Our Ref: EN070001

Date: 18 March 2015

Application by National Grid Carbon Ltd for an Order Granting Development Consent for the Yorkshire and Humber CCS Cross Country Pipeline

Request for further information relating to the applicant's draft Development Consent Order (DCO)

**DRAX PIG TRAP  
PLANNING ARRANGEMENT**

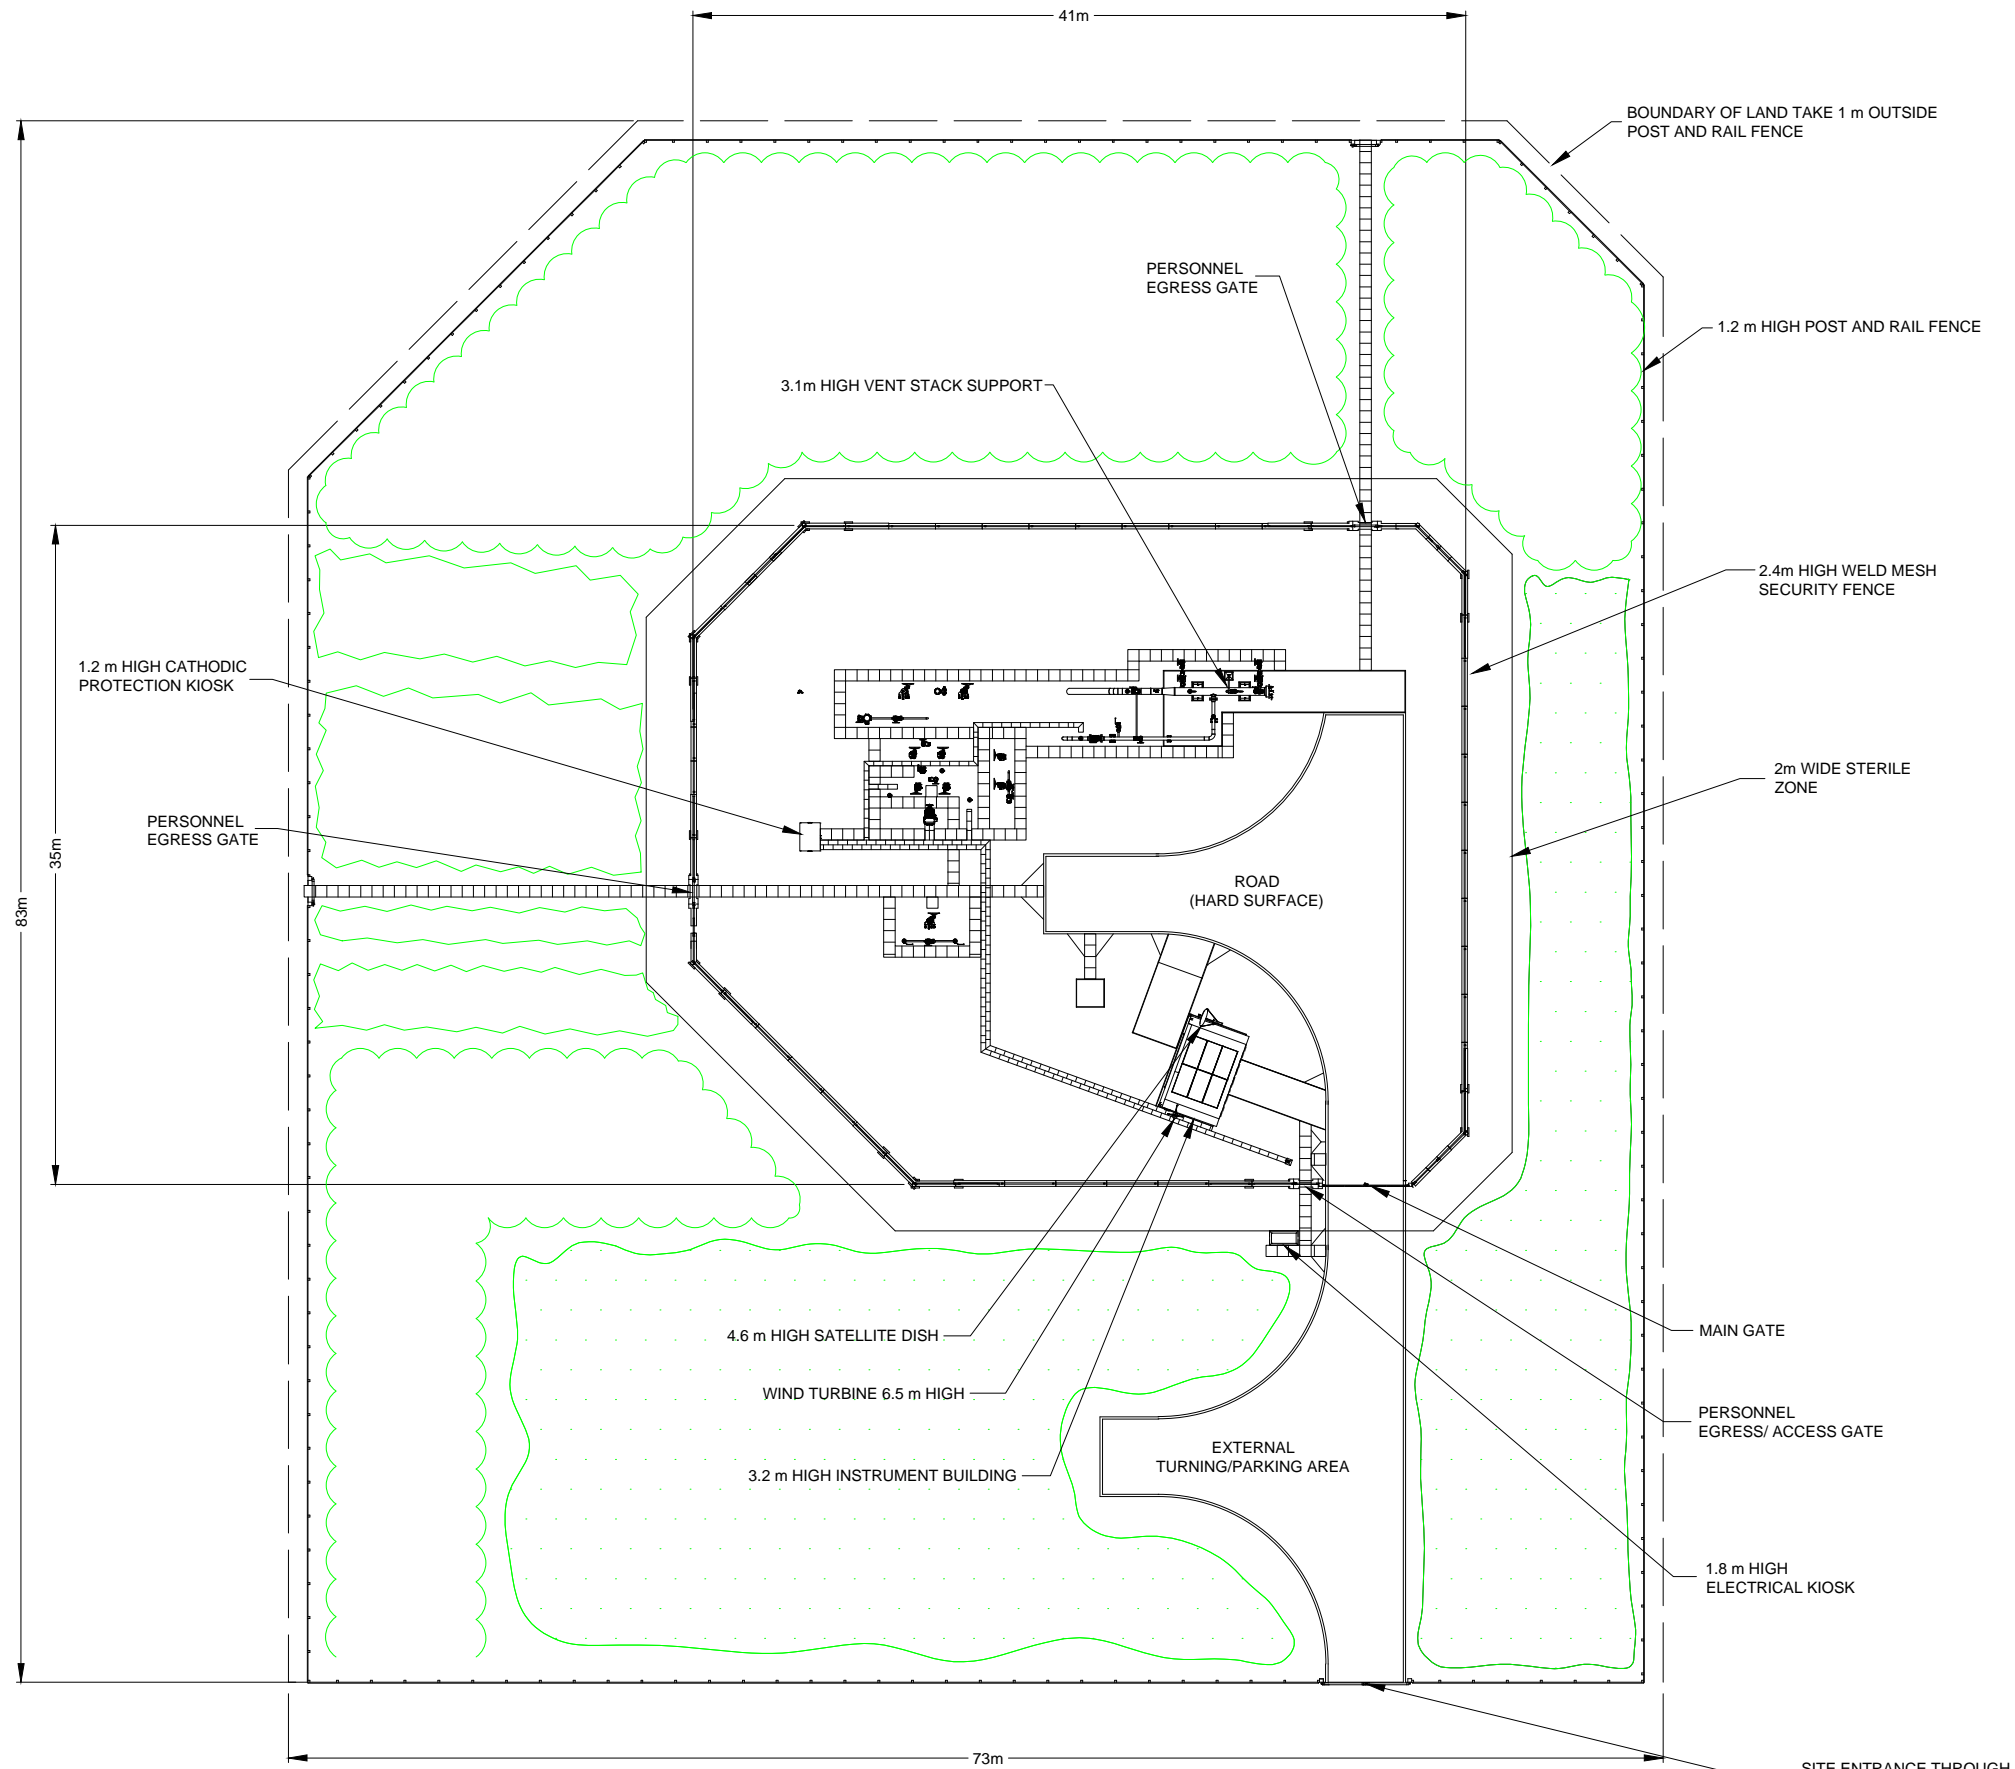
With regard to the Drax Pig Trap, the revised draft DCO received at deadline 4 and revised plans 2.18, 2.19, 2.20 and 2.22 also received at deadline 4 show an increase in the height of the security fence from 2.4m to 2.88m. This height appears to have been gained by the addition of three strands of barbed wire above the weld mesh security fence. These revised plans now reflect the fencing arrangements at other above ground installations (AGIs).

Please can the applicant confirm how this increase in height will impact upon the assessment of visual impact made in the Environmental Statement?

Please could Selby District Council comment on whether the additional 0.48m height of the security fence affects their assessment of the visual impact of the Drax Pig Trap?
